**NEWCASTLE COAL INFRASTRUCTURE GROUP RAIL FLYOVER MODIFICATION  
ENVIRONMENTAL ASSESSMENT**

**DETAILED RESPONSES TO OEH SUBMISSION – PART B**

FIGURE 4

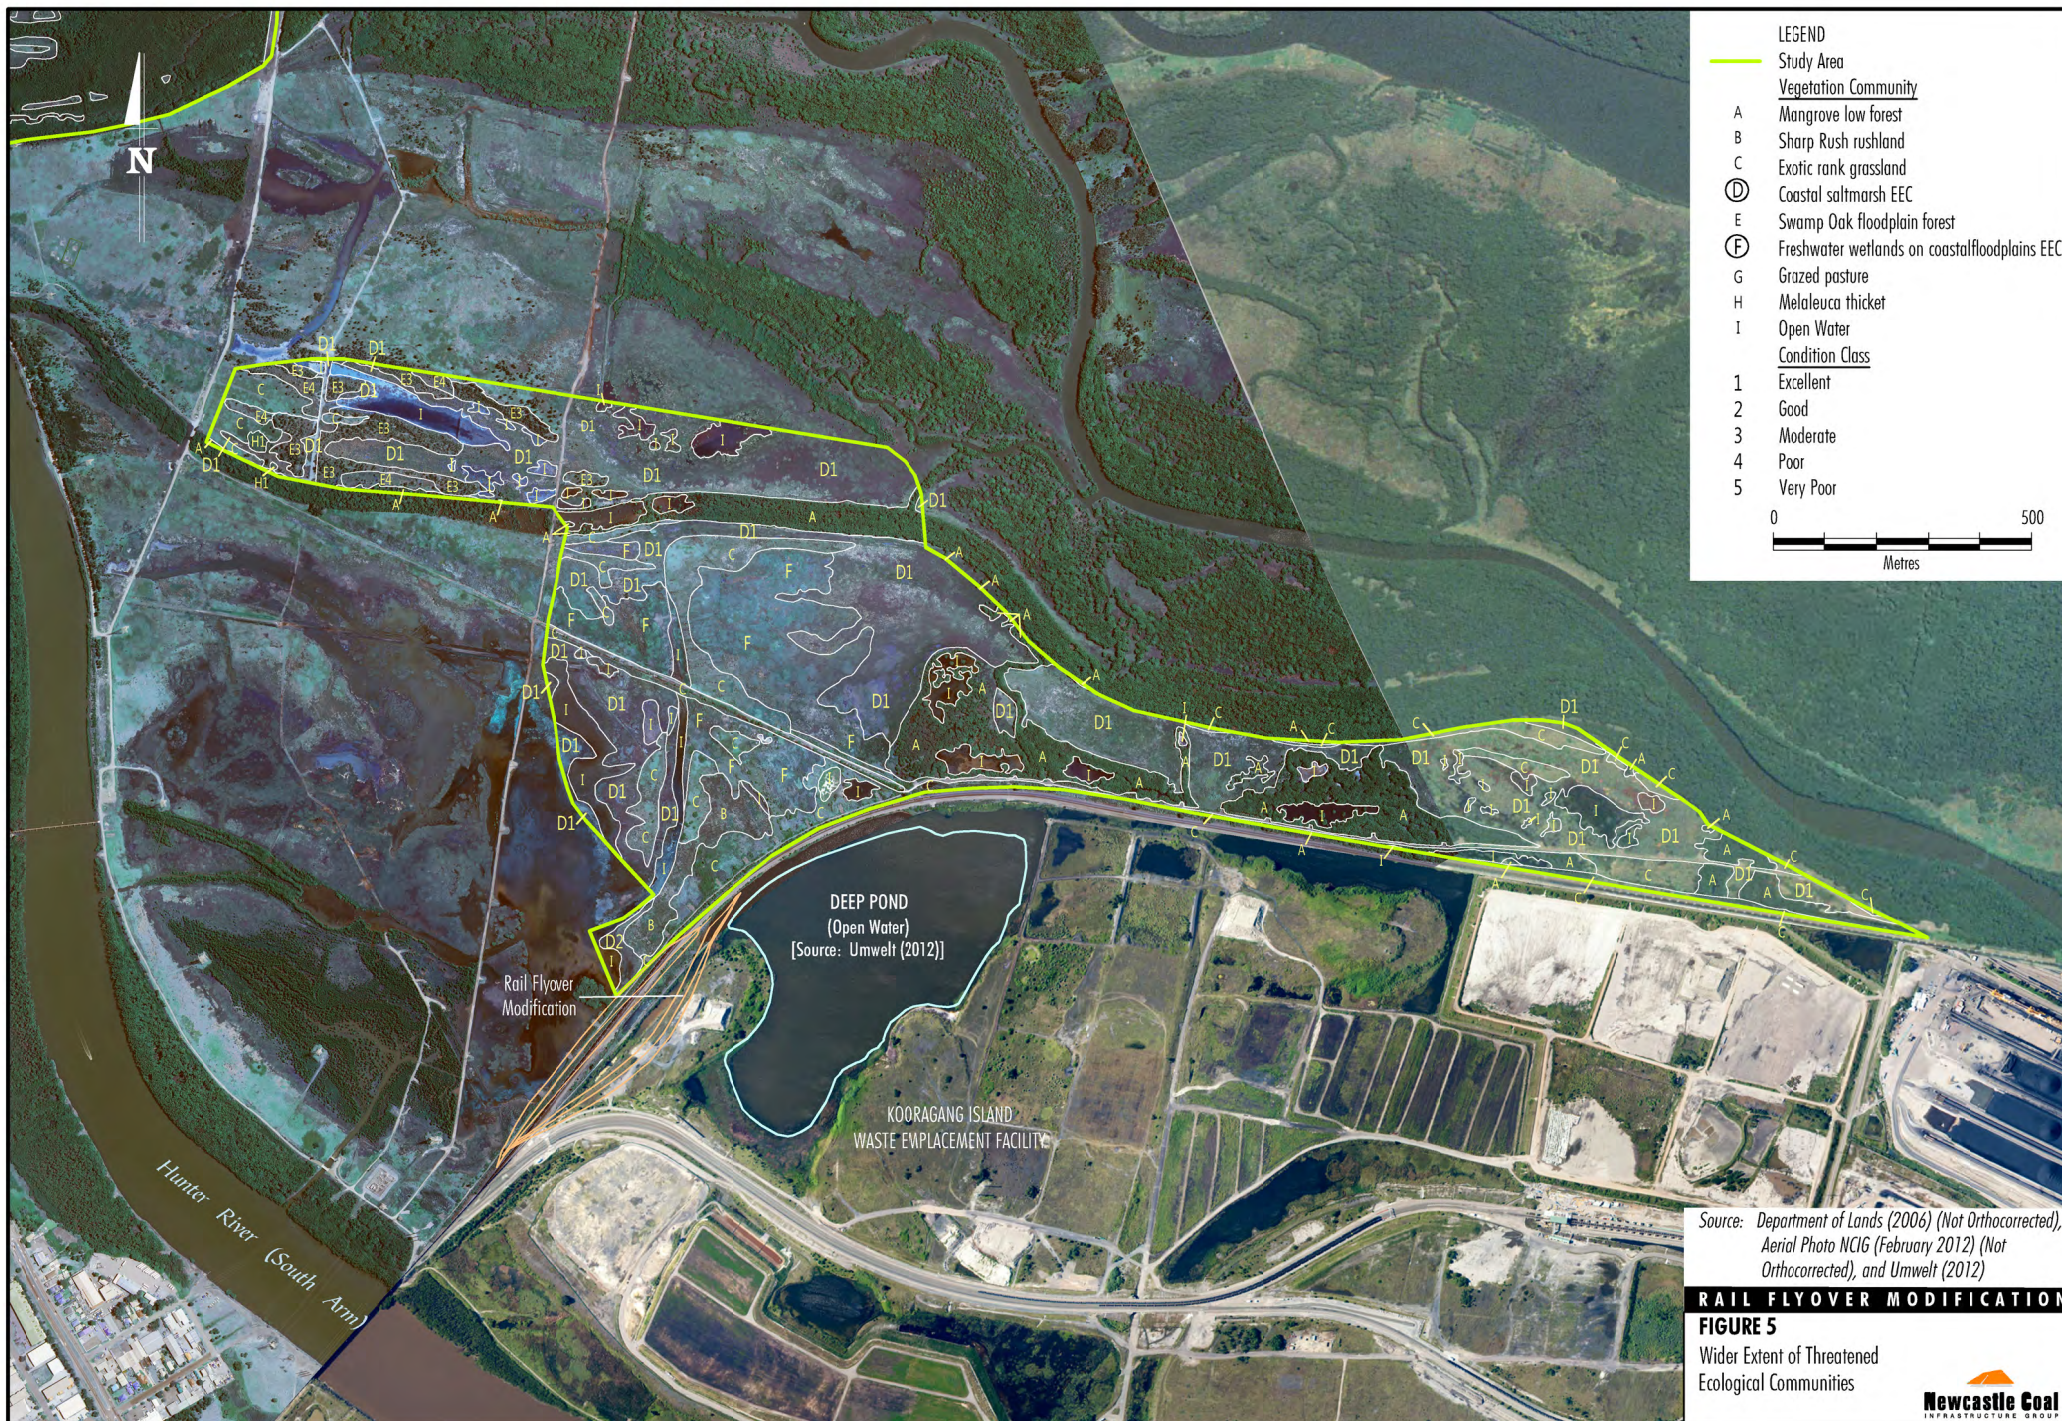
No.	Subject	OEH Statement/Request	Response
B18	Threatened Species Assessment	<i>OEH has not completed a detailed review of the threatened species assessment section of the EA, as some of the surveys may not have been undertaken, namely the fauna baseline and targeted searches.</i>	The appropriate fauna surveys and targeted searches are detailed in the TSA presented in the EA.
B19	Threatened Species Assessment	<i>Furthermore, OEH believes that the proposal has underestimated the impact on the wetland habitat of the site, given that OEH are of the opinion it represents important roosting, breeding and foraging habitat to a number of migratory waterbirds /shorebirds, including known listed threatened species under the TSC Act.</i>	The impact on the wetland habitat west of the existing Kooragang Island Main Line has not been underestimated. Section 4.9 (of the Rail Flyover Modification EA) describes how a linear strip of Saltmarsh (1.32 ha) on the west of the existing rail embankment would be removed.
